Your Ref: OWPC23859
Our Ref: R/72/19/PL 02-04-2019
Please ask for:
Mrs A Gardner

Demolition of existing garage & store on existing dwelling & construction of 2 new dwellings in rear garden.

6 Manor Road Rustington

DRAWING No: DS/6MANOR/03 rev 4

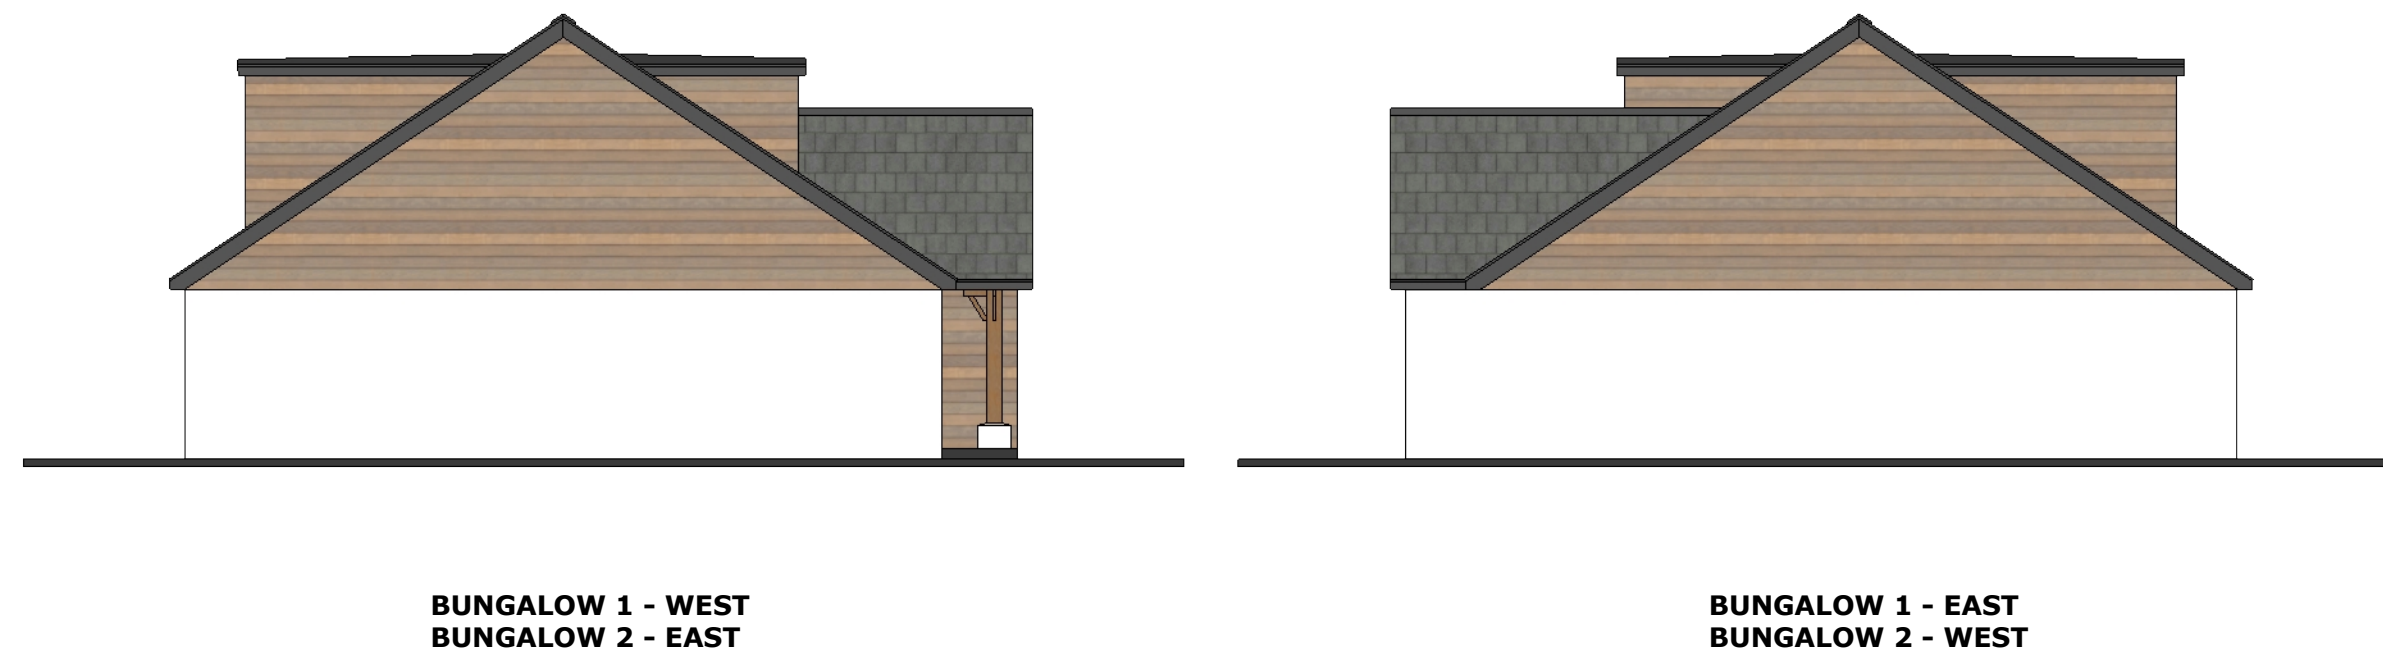
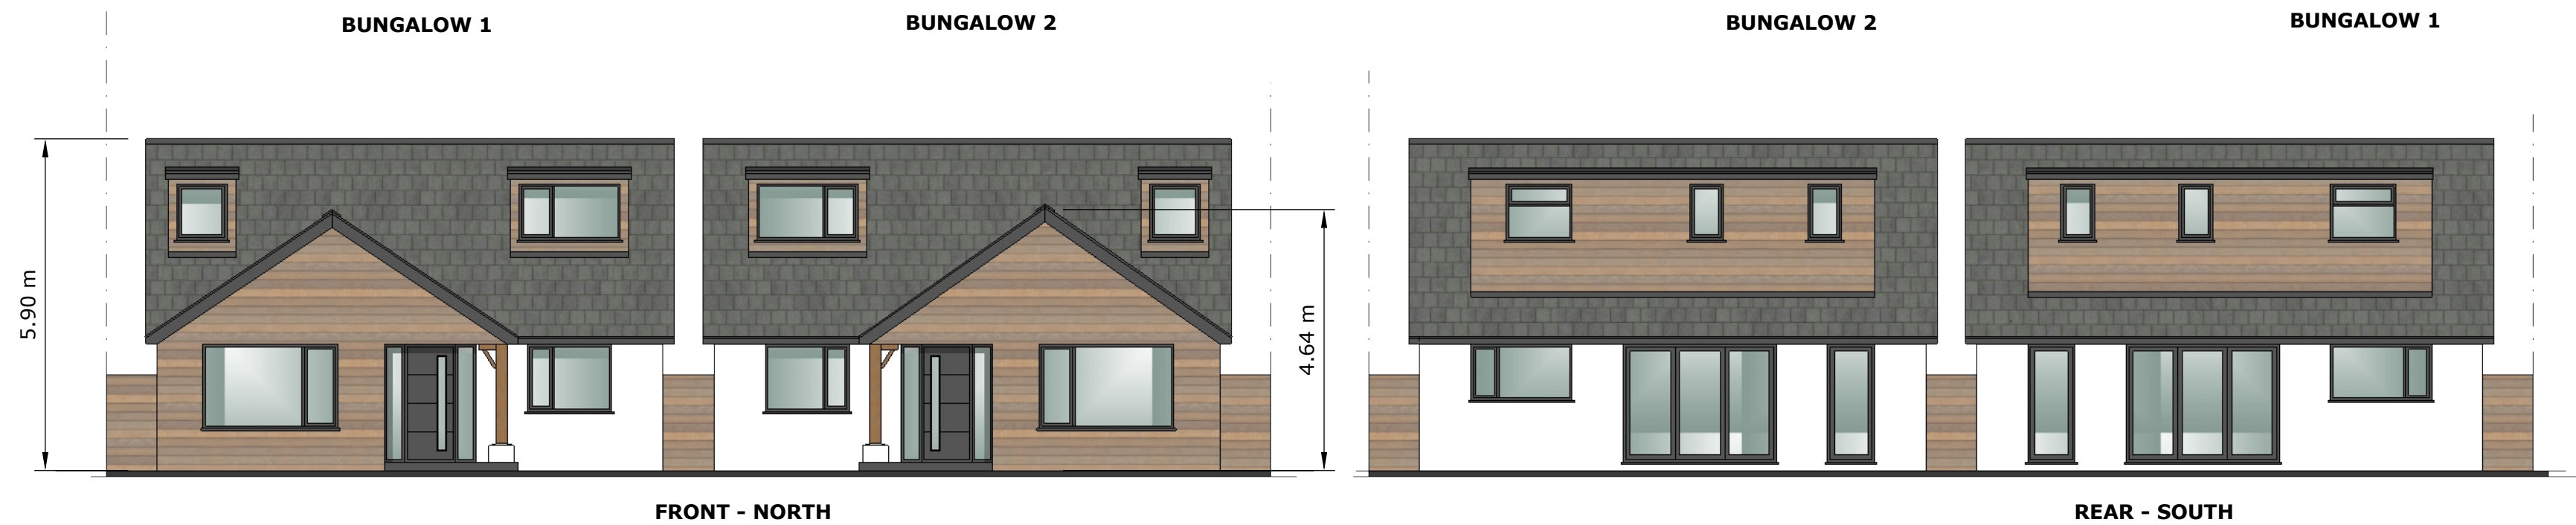
The proposed properties are still out of line with the properties in Grafton Close and now the added window will cause an even bigger issue to the privacy of 1, Grafton Close.
